## Development Application and Planning Proposal Review

Authority	Authority's Reference	Authority Contact	Authority Notification	Submission Due	Submission Made
NSW Planning, Industry & Environment	SSD-36156297; SSD-5248-Mod-2	Bruce Zhang	10/05/2022	8/06/2022	12/05/2022

Address	Land Title
813-913 Wallgrove Road, Horsley Park	Lot 100 DP 1268340

Environmental Impact Statement for SSD-36156297 DHL Warehouse and Distribution Centre. Construction and operation of a warehousing and distribution centre in Gazcorp Industrial Estate with a total gross floor area of 31,860 square metres to be used by DHL.

TITLE:
SITE PLAN

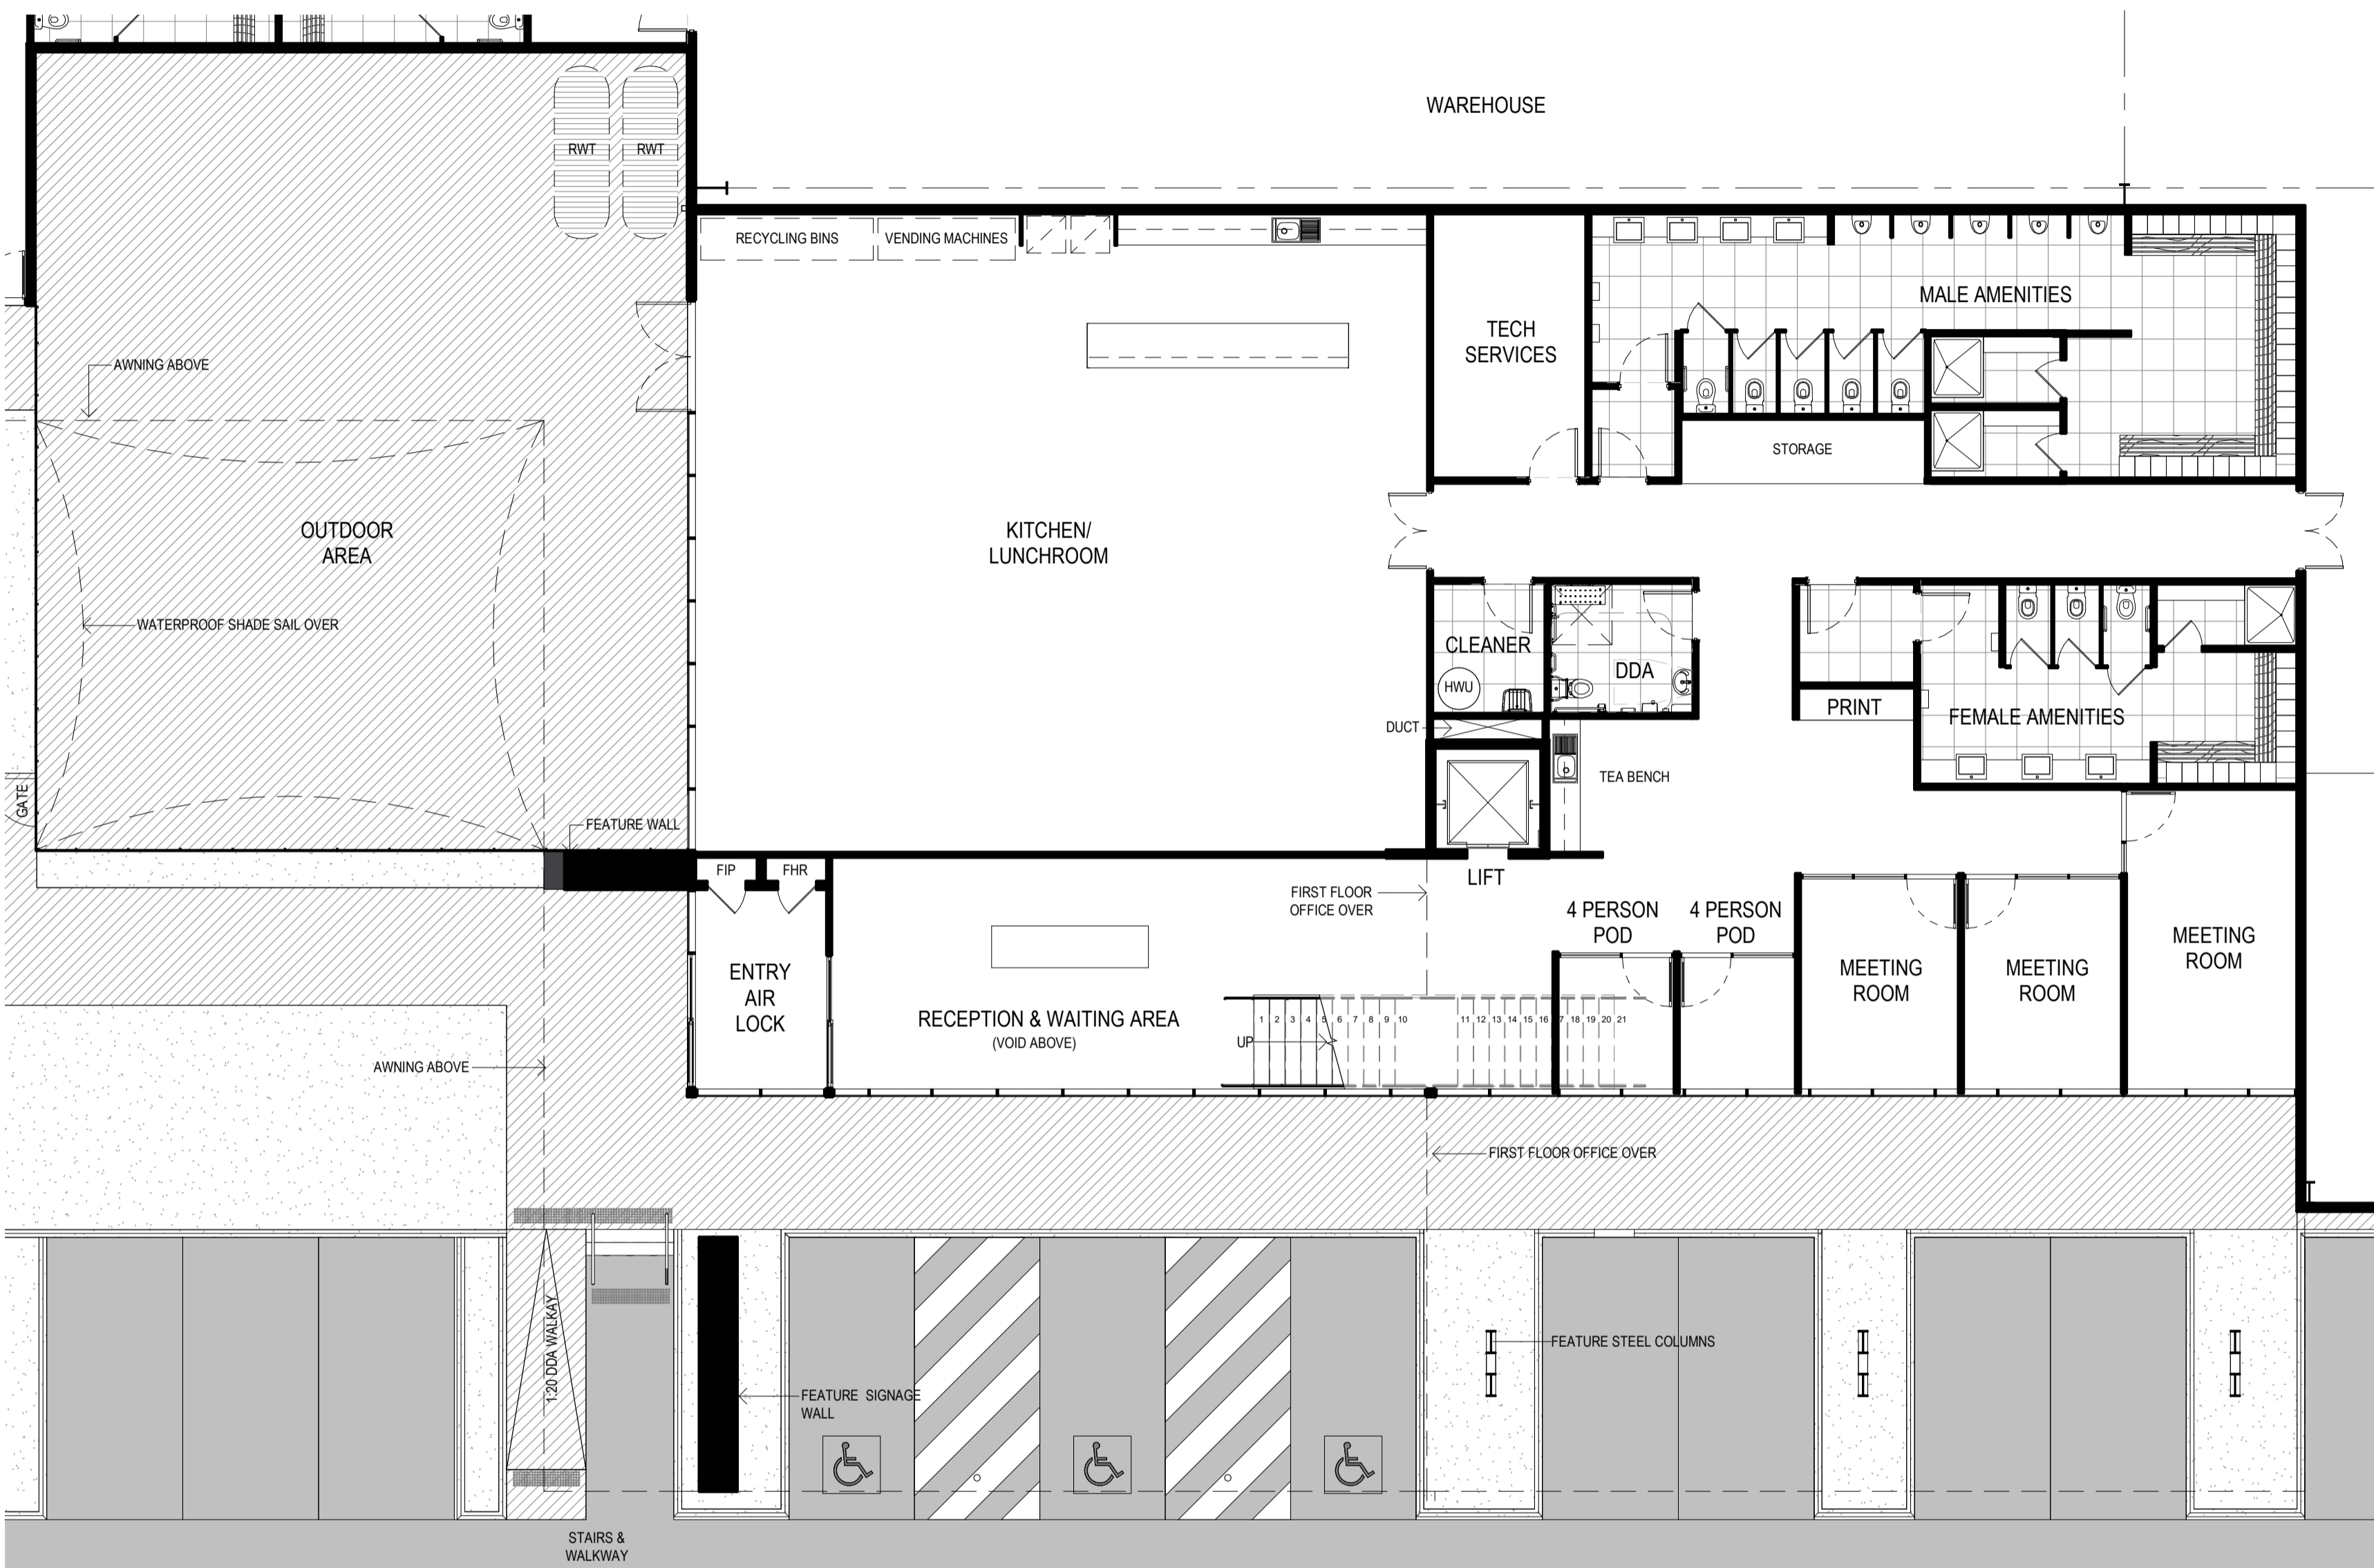
Endeavour Energy	
Completed by:	Decision
Cornelis Duba	Approve (with conditions)
Reason(s) for Conditions / Objection (If applicable)	
<ul style="list-style-type: none"> <li>The Environmental Impact Statement does not appear to address in detail whether the electricity services are available and adequate for the proposed development.</li> </ul> <p><b>3.9 Utilities and Infrastructure</b></p> <p>The Site is not currently serviced, however utilities, services and infrastructure will be provided to the site and reticulated throughout the estate as part of the Stage 1 estate works under SSD 5248 – including sewer, electricity, water supply and telecommunications. No changes to the provision of infrastructure, utilities and services to the estate is proposed in this development application.</p> <ul style="list-style-type: none"> <li>To ensure an adequate connection, the applicant will need to engage an Accredited Service Provider (ASP) of an appropriate level and class of accreditation to assess the electricity load and the proposed method of supply for the development.</li> <li>An extension and / or augmentation of the existing local network will be required. As well as the provision of padmount substations, other factors such as the size and rating / load on the conductors and voltage drop (which can affect the quality of supply particularly with long conductor runs) etc. need to be assessed. In this instance any additional feeders would likely need to be provided from Endeavour Energy’s Emu Plains Zone Substation located approximately 740 metres to the west at 162-168 Russell Street Emu Plains. However the extent of any works required will not be determined until the final load assessment is completed.</li> <li>The Site Plan from the DHL Warehouse Architectural Plans shows provision has been made for two padmount substations indicated as ‘Substations Shown Indicative Only’.</li> <li>The required padmount substations will need to be located within the property (in a suitable and accessible location) and be protected (including any associated cabling) by an easement and associated restrictions benefiting and gifted to Endeavour Energy. Please refer to Endeavour Energy’s Mains Design Instruction MDI 0044 ‘Easements and Property Tenure Rights’.</li> <li>Generally it is the Level 3 Accredited Service Provider’s (ASP) responsibility (engaged by the developer) to make sure substation location and design complies with Endeavour Energy’s standards the suitability of access, safety clearances, fire ratings, flooding etc.</li> <li>Endeavour Energy is urging applicants /customers to engage with an Electrical Consultant / Accredited Service Provider (ASP) prior to finalising plans to in order to assess and incorporate any required electricity infrastructure. In so doing the consideration can also be given to its impact on the other aspects of the proposed development. This can assist in avoiding the making of amendments to the plan or possibly the need to later seek modification of an approved development application.</li> <li>The minimum required safety clearances and controls for buildings and structures and working near overhead power lines must be maintained at all times. If there is any doubt whatsoever regarding the safety clearances to the overhead power lines, the applicant will need to have the safety clearances assessed by a suitably qualified electrical engineer / Accredited Service Provider (ASP).</li> </ul>

- The planting of large / deep rooted trees to near electricity infrastructure is opposed by Endeavour Energy. Existing trees which are of low ecological significance in proximity of electricity infrastructure should be removed and if necessary replaced by an alternative smaller planting. The landscape designer will need to ensure any planting near electricity infrastructure achieves Endeavour Energy's vegetation management requirements.
- Not all the conditions / advice marked may be directly or immediately relevant or significant to the Development Application. However, Endeavour Energy's preference is to alert proponents / applicants of the potential matters that may arise should development within closer proximity of the existing and/or required electricity infrastructure needed to facilitate the proposed development on or in the vicinity of the site occur.
